Re: Existing Tank Application: # BRES2204-0085

An attempt was made to evaluate your property for the purpose of issuing an existing tank permit. The evaluation could not be completed for one or more of the following reasons.

House Plans  
First Floor

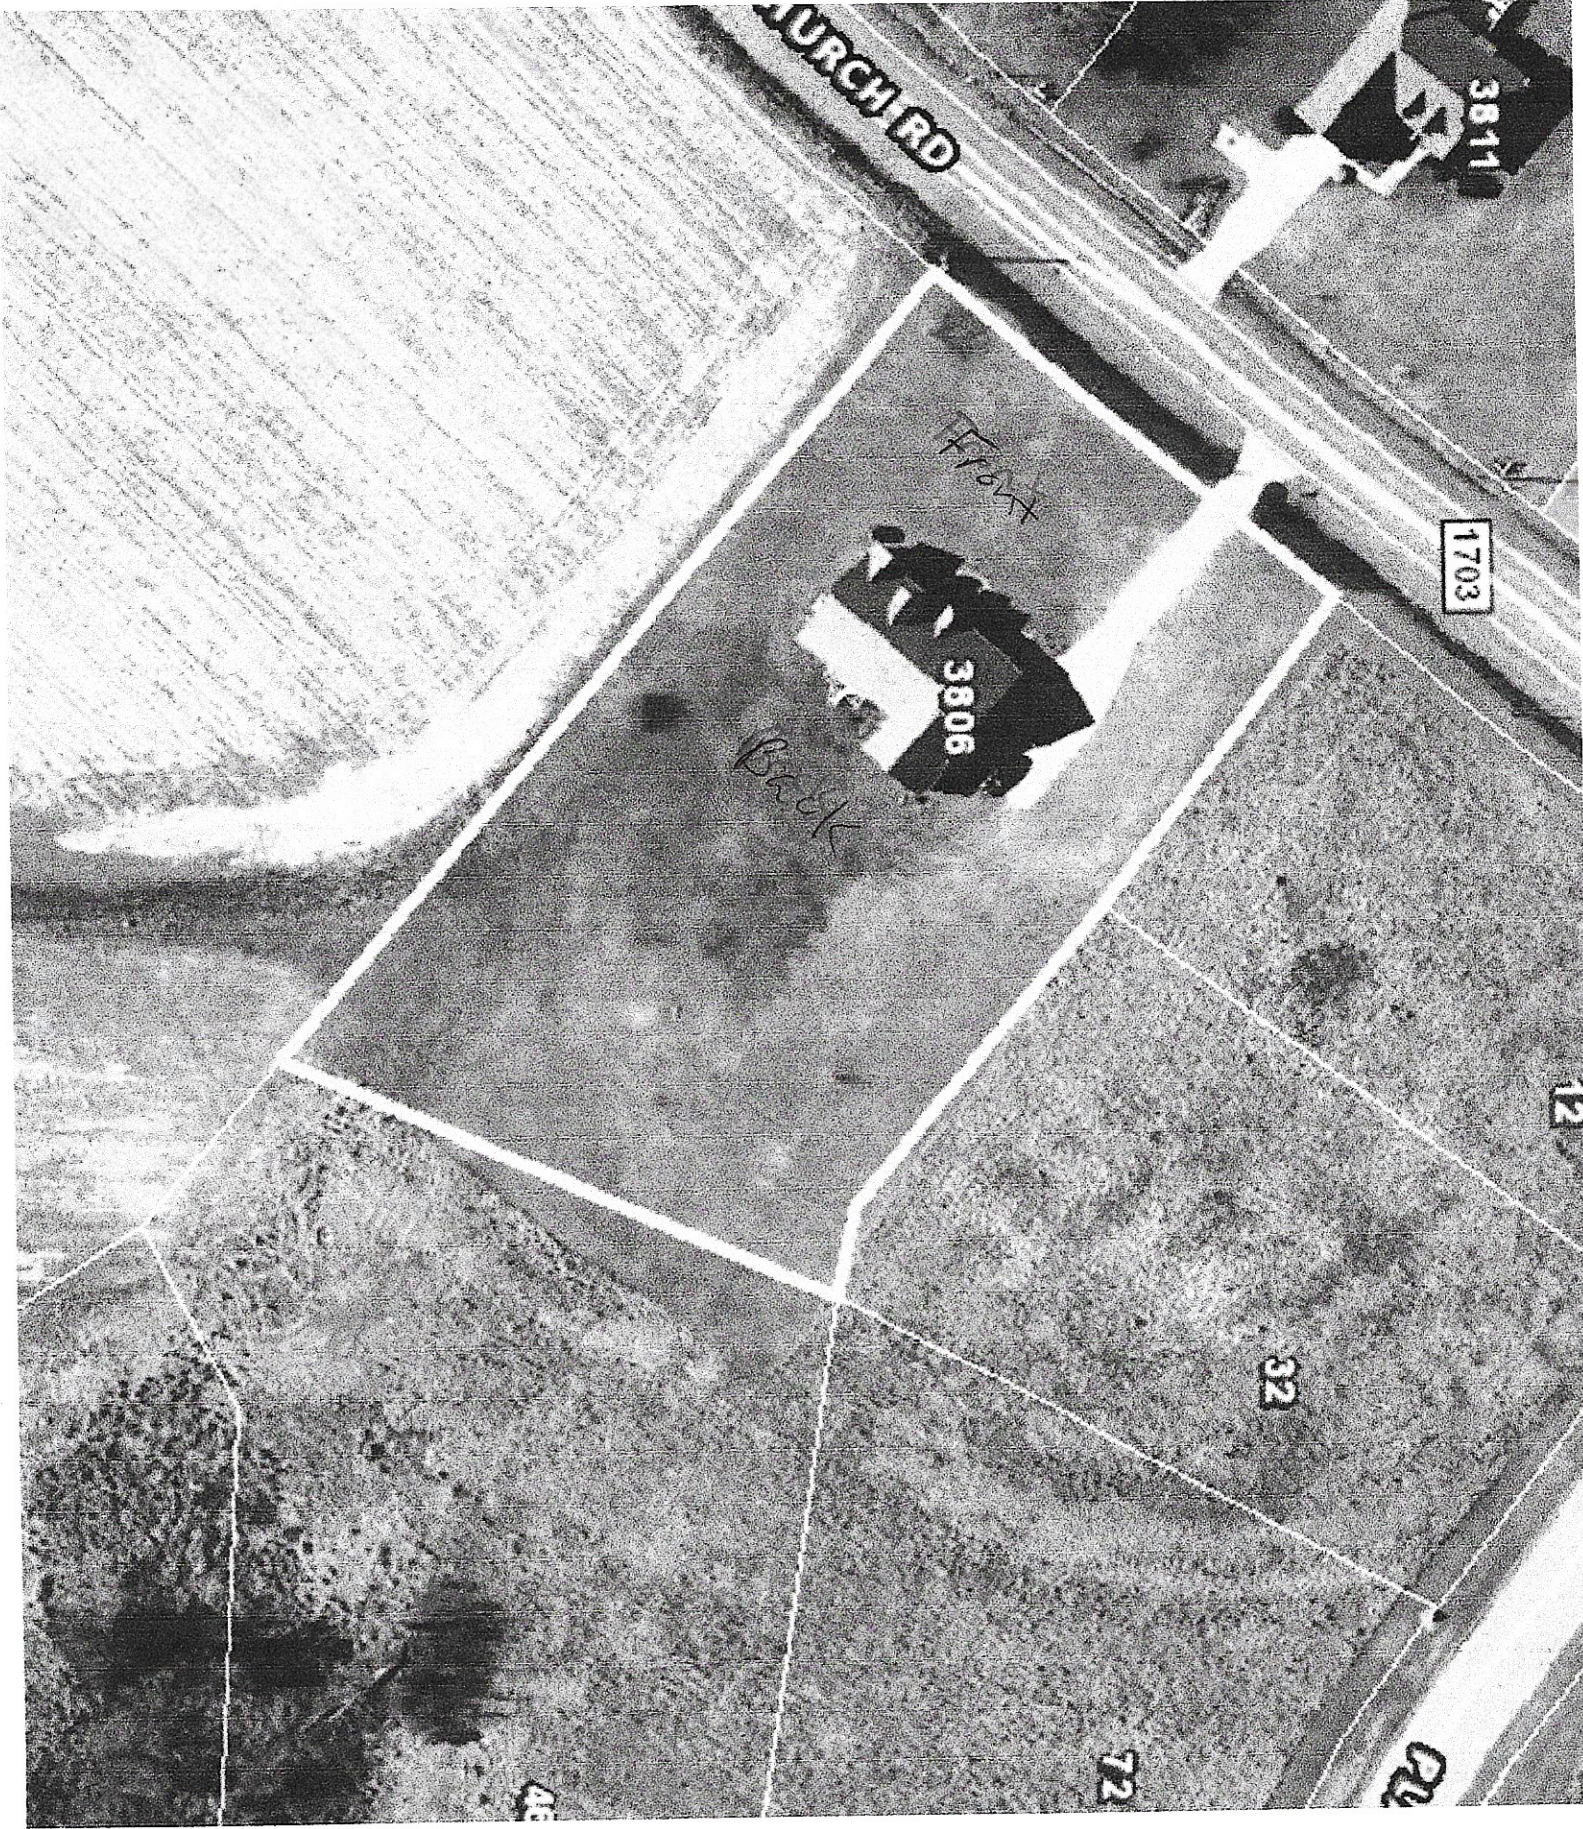
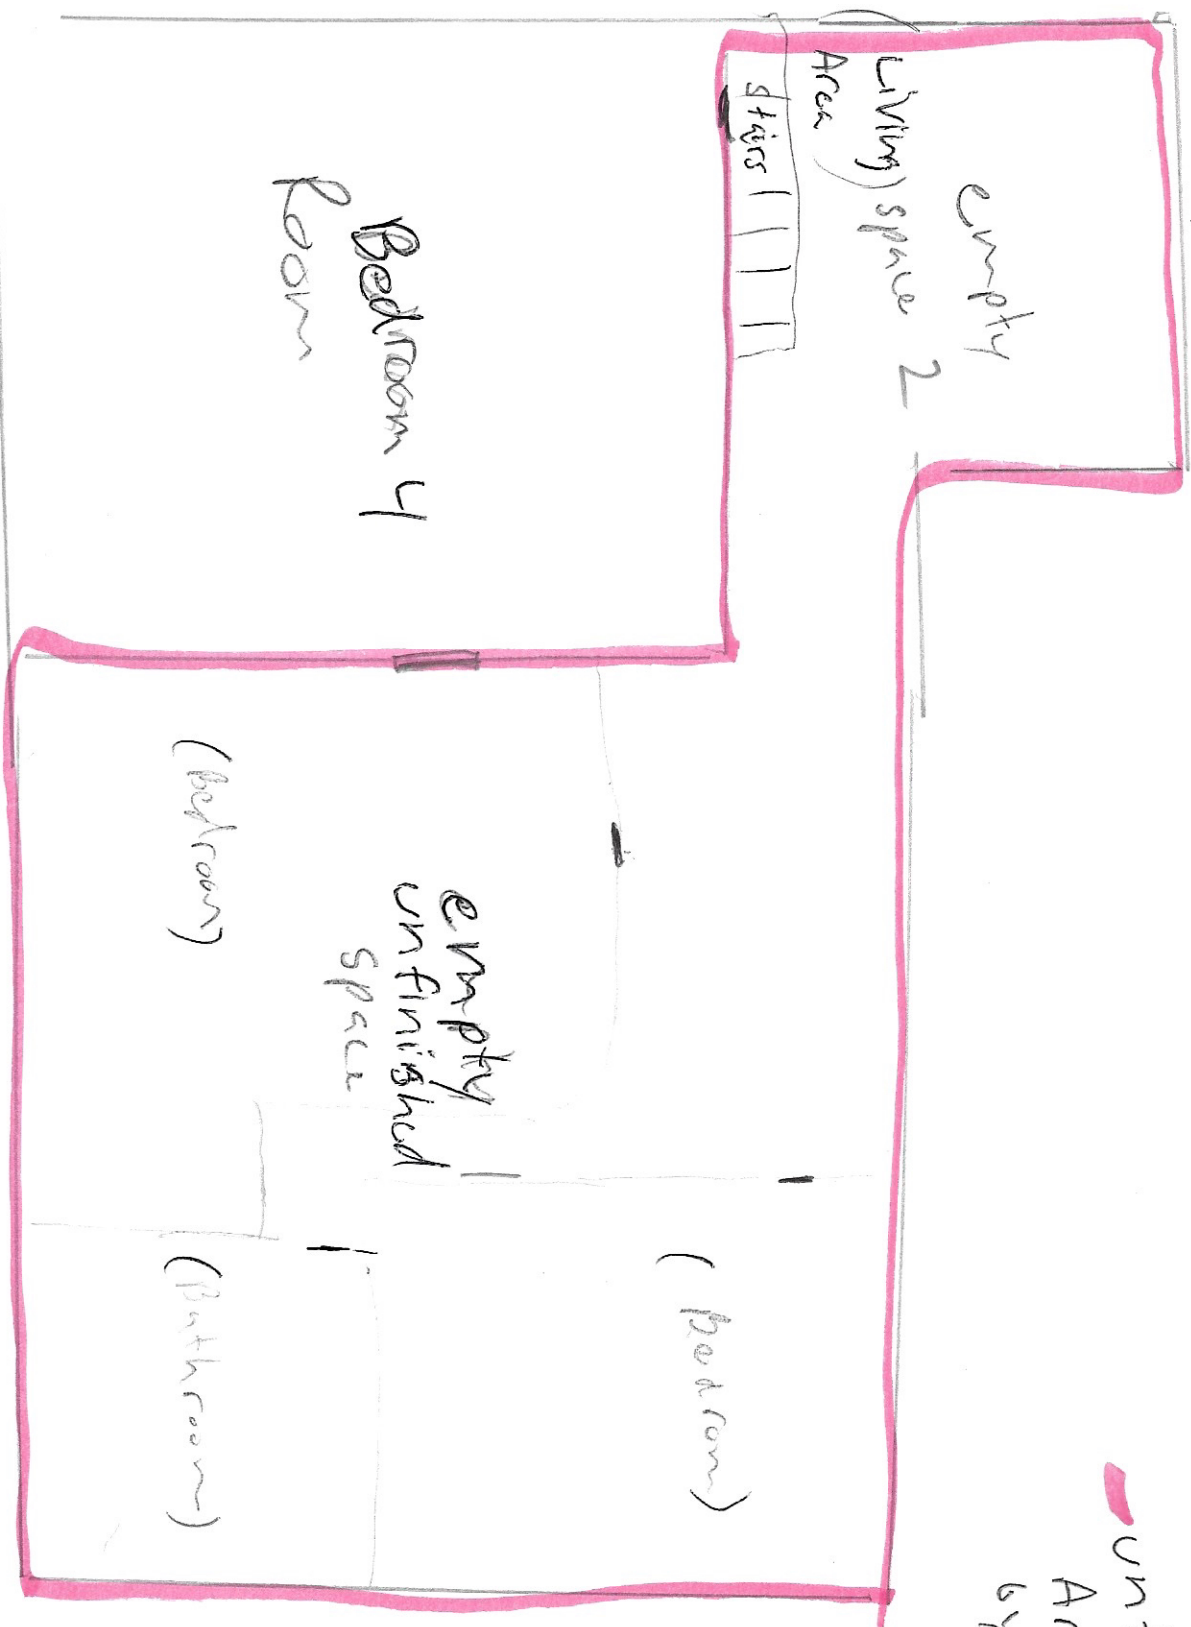
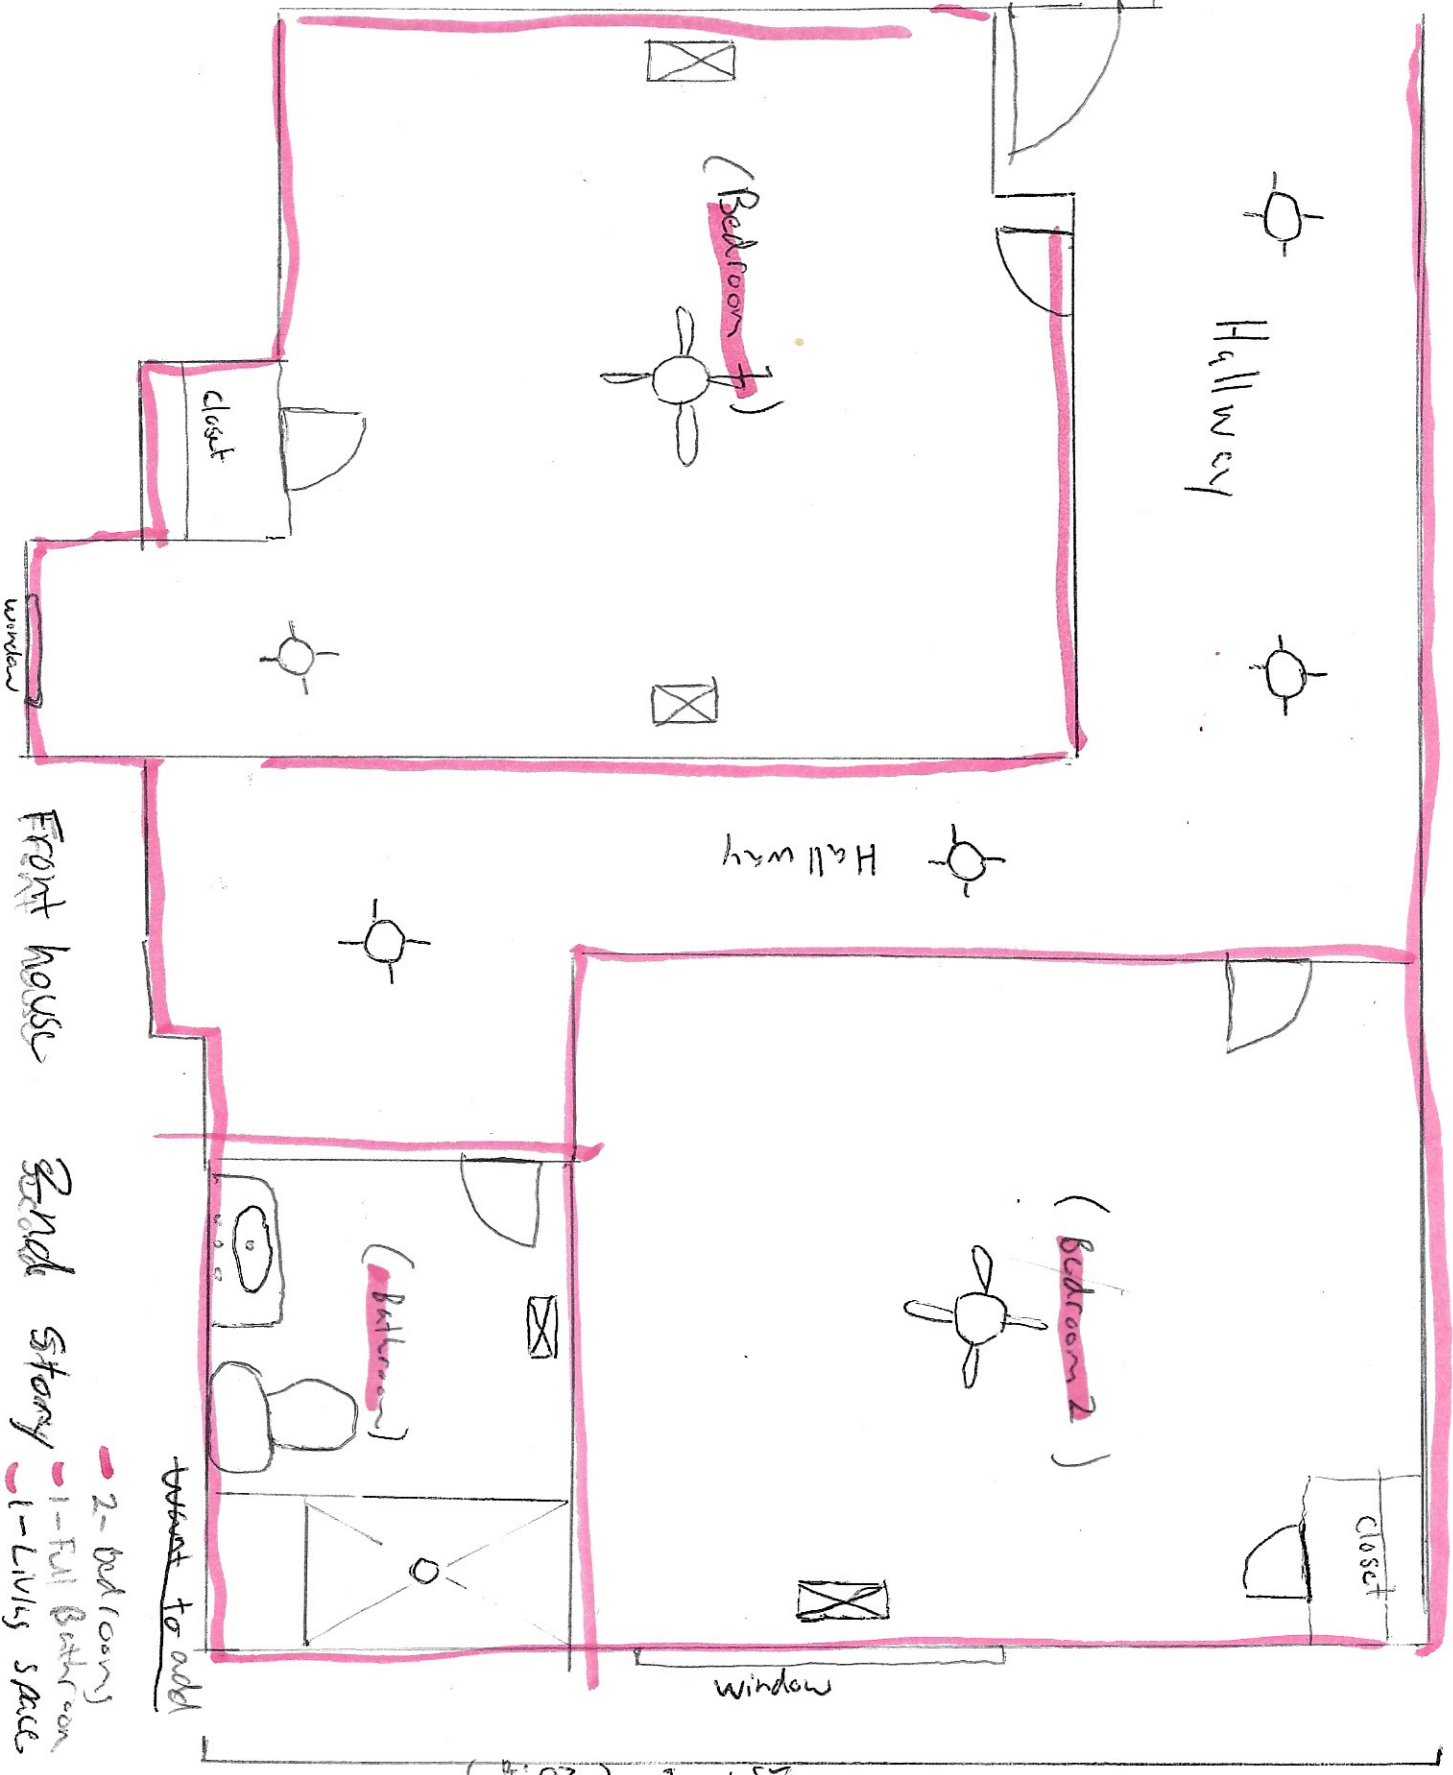
4. Other – Existing tank denied as applied. Applicant applied for existing tank. Paperwork reflects request for bedroom additions which require septic system expansion. Expansion septic systems application and fees required prior to proceeding. Due to requested bedroom amount (6) and site considerations, expansion permit cannot be guaranteed approval. Site was built and septic sized as 3-bedroom SFD. A 6-bedroom SFD would be an extensive septic system expansion including additional drain field, larger tank, etc. Homeowner advised to provide private soil consultant layout and proposal if guarantee is requested prior to expansion application filed.
